CITY OF ALBUQUERQUE

April 14, 2021

Re: JB Hendrson Fabrication Facility
10200 Bell Ave. SE
Traffic Circulation Layout
Architect's Stamp 01-15-2021 (L21-D075)

AS-101

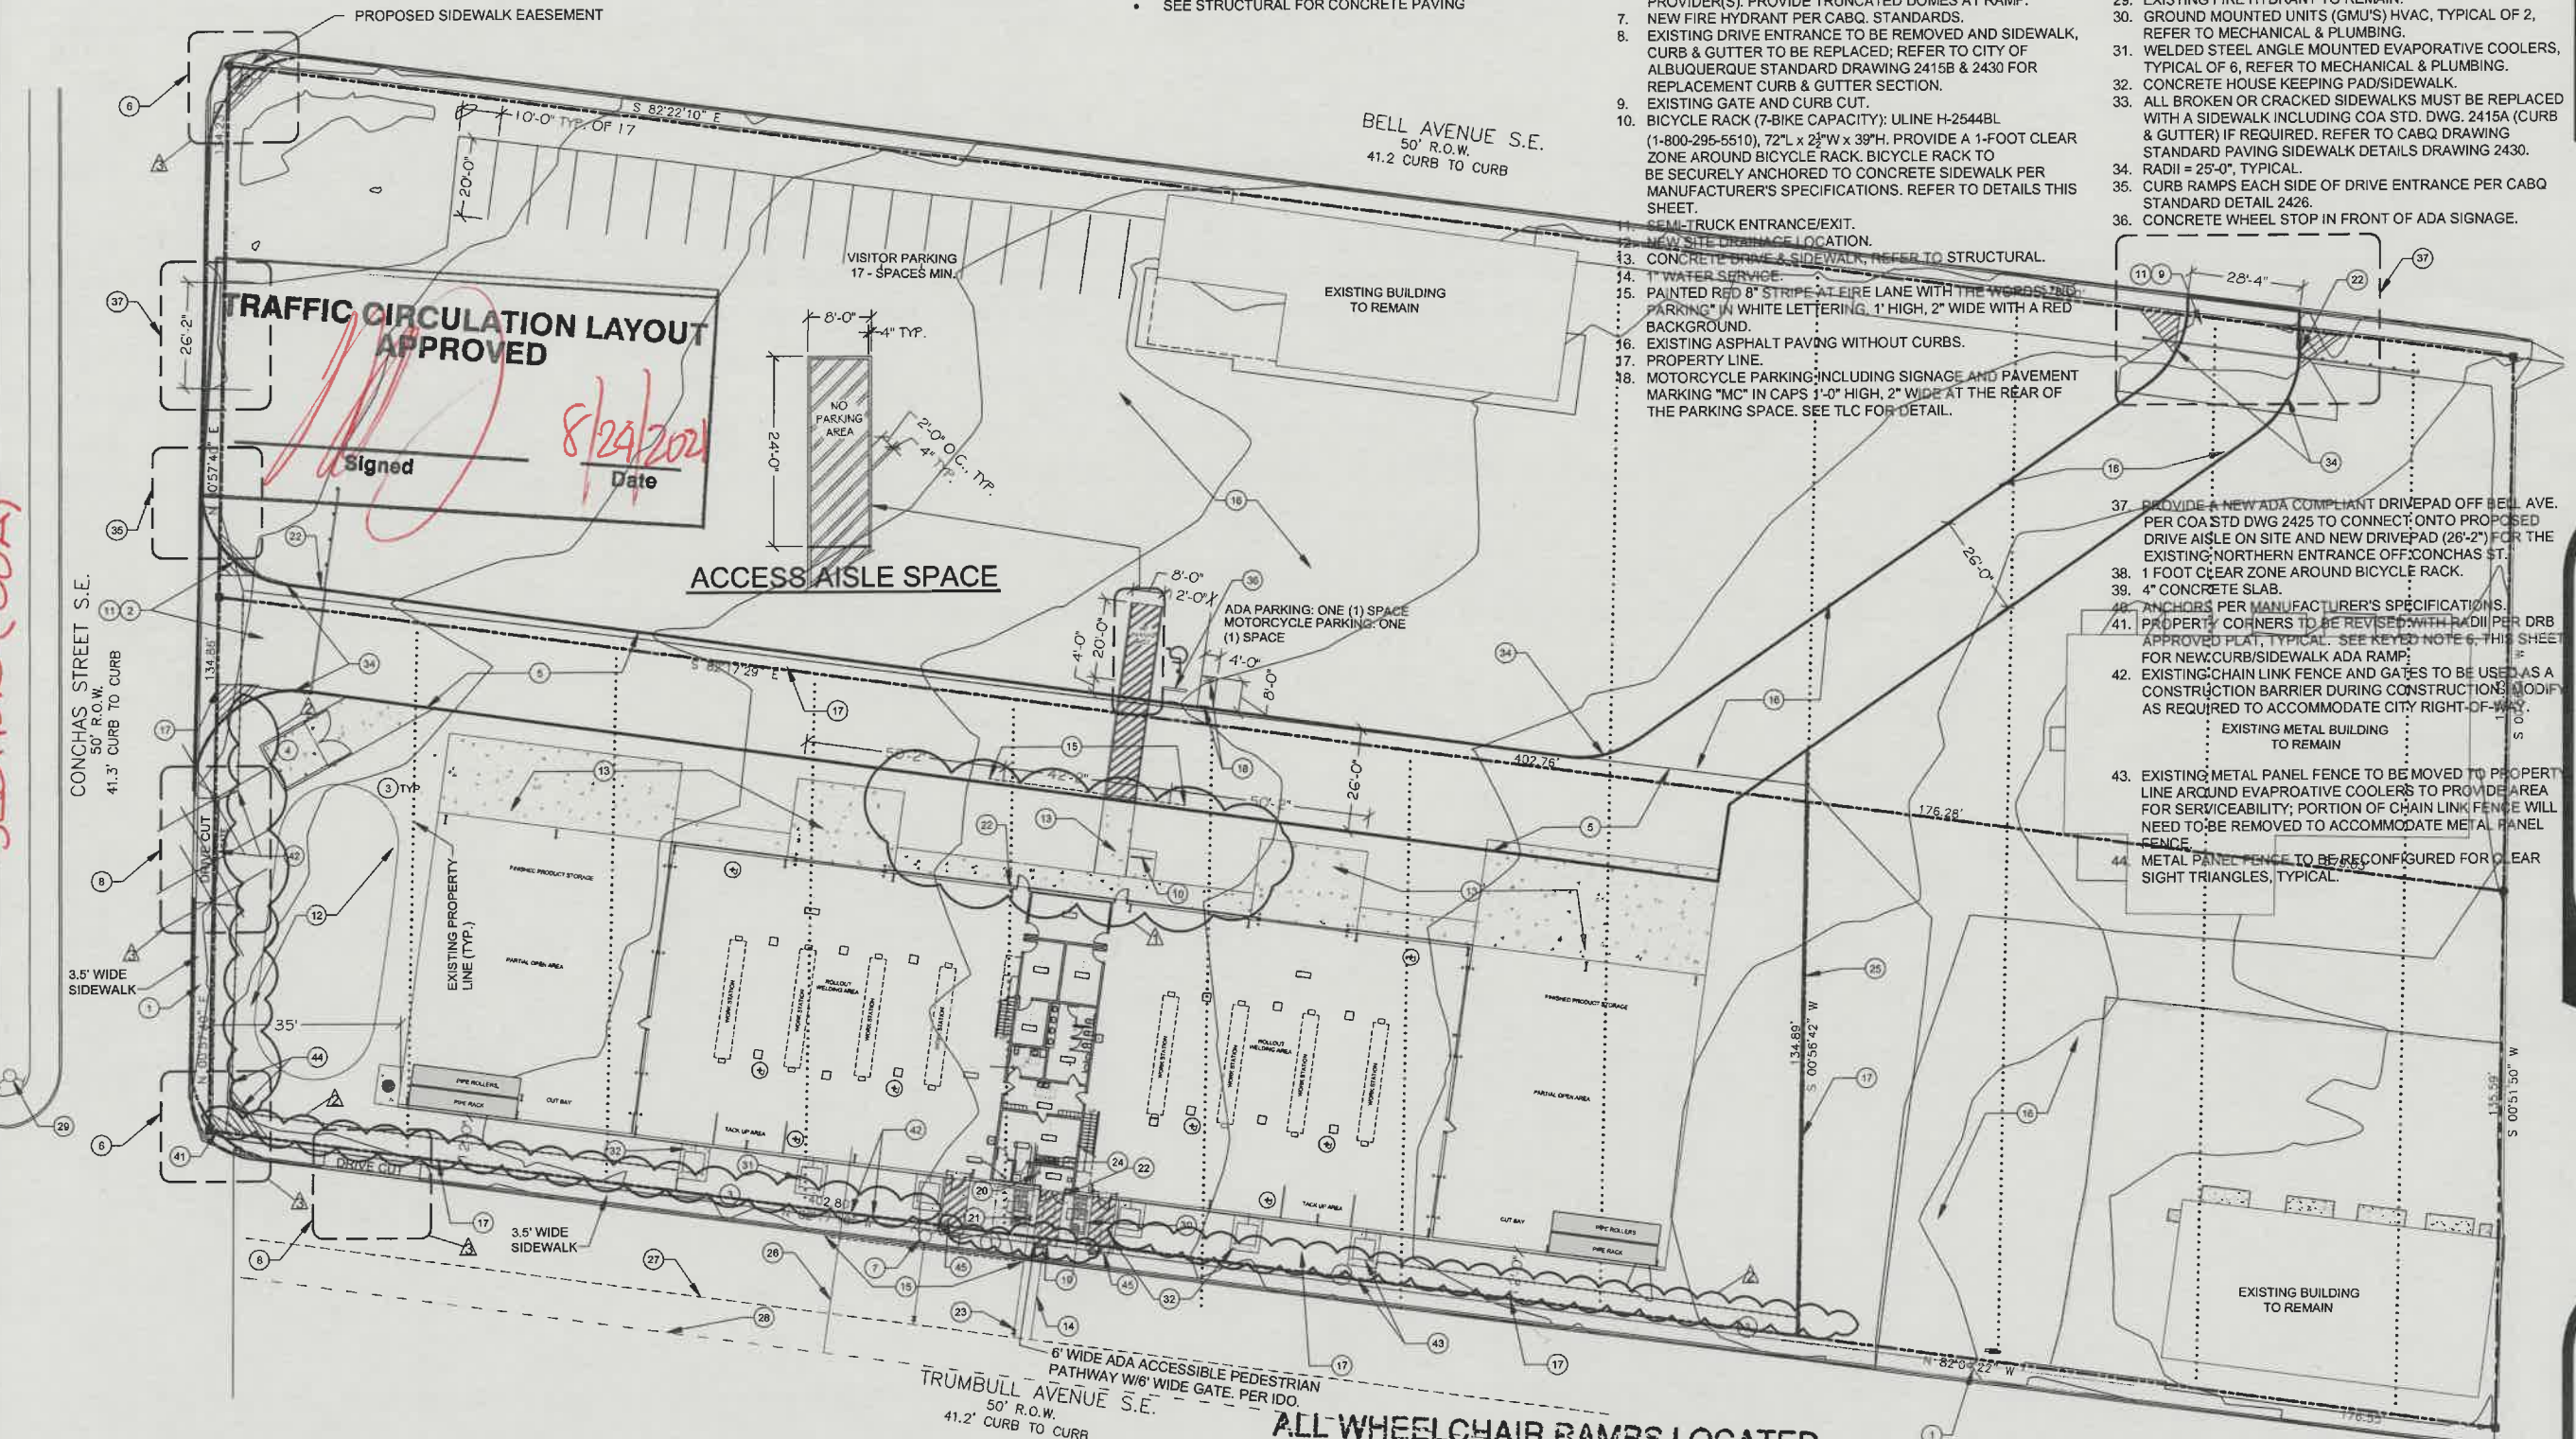
1. List the number of parking spaces required by the IDO as well as the proposed number of parking spaces including bicycle and motorcycle parking and discuss with Zoning.

2. Clarify the extents of the current phase. Provide a phasing plan.
3. Provide details for all referenced key notes on Site Plan.
4. Drive aisle connection at Bell Ave.: a diagonal drive aisle from is shown with a connection into Bell Ave. Are there any existing/proposed driveway to service this drive aisle? Please provide details (width of aisle, detail of proposed driveway).

5. The proposed drive aisle on site doesn't show how a vehicle will be able to access parking lot since the proposed aisle boundaries aren't shown if there is curbing to traverse over to existing parking lot.

6. Identify all existing access easements and rights of way width dimensions.
7. Identify the **right of way width**, medians, **curb cuts**, and **street widths** on Bell Ave, Conchas St., and Trumbull Ave.

8. Clarify existing property lines and proposed property lines. The property lines appear to be different from AGIS. Please clarify this concern.
9. Conchas St. proposed entrance (**curb returns**): You need to show/provide ADA ramp with truncated domes for the proposed curb returns (**See note 16 on this letter**). **Since there are no ADA ramps at these two corners, you will have to include a note to provide ADA ramps and address the property line issue within these parameters as well as providing details for these ramps.**

11. All existing public sidewalk widths need to be shown.
12. **Please list the width and length for all existing and proposed parking spaces. Some dimensions are not shown.**
13. The minimum parking stall dimensions are **(some dimensions not shown)**:

16. ADA curb ramps must be updated to current standards and have truncated domes installed with Public ROW (**corner of Bell/Conchas and Conchas/Trumbull**).

17. **Motorcycle parking spaces shall be designated by its own conspicuously posted upright sign, either free-standing or wall mounted per the zoning code. Label pavement MC.**

20. A 1-foot clear zone around the bicycle parking stall shall be provided.
21. Bicycle parking spaces shall be at least 6 feet long and 2 feet wide.
22. Show all drive aisle widths and radii. Some dimensions are not shown.
23. The minimum drive aisle dimensions are shown below

24. Per the IDO, a **6 ft. wide ADA accessible pedestrian pathway** is required from the public sidewalk to the building entrances. **Please clearly show this pathway and provide details.**

25. Per DPM, a **6 ft. wide ADA accessible pedestrian pathway** is required from the ADA parking stall access aisles to the building entrances. **Please clearly show this pathway and provide details.**

27. All sidewalks along streets should be placed at the property line.
28. Curbing should be installed to delineate landscape, parking, and pedestrian ways and identify points of access. Please call out detail and location of barrier curb.

30. Please provide a sight distance exhibit
31. Show the clear sight triangle and add the following note to the plan: "Landscaping and signage will not interfere with clear sight requirements. Therefore, signs, walls, trees, and shrubbery between 3 and 8 feet tall (as measured from the gutter pan) will not be acceptable in the clear sight triangle.

32. Please specify the City Standard Drawing Number when applicable.
33. **Shared Site acces: driveways that straddle property lines, or are entirely on one propertybut are to be used by another property, shall have an access easement. Please include a copy of your shared access agreement with the adjacent property owner.**

36. Any private structures that are located within public right-of-way such as **gate/door**, fences and walls shall either be removed or else a revocable permit with the City is required in which an annual fee is paid per year, based on square footage of the encroachment

37. Unused curb cuts must be replaced with sidewalk and curb & gutter. A build note must be provided referring to the appropriate City Standard drawings (2430 & 2415). Identify on plans off Bell Ave, **Conchas Street** and Trumbell Ave.
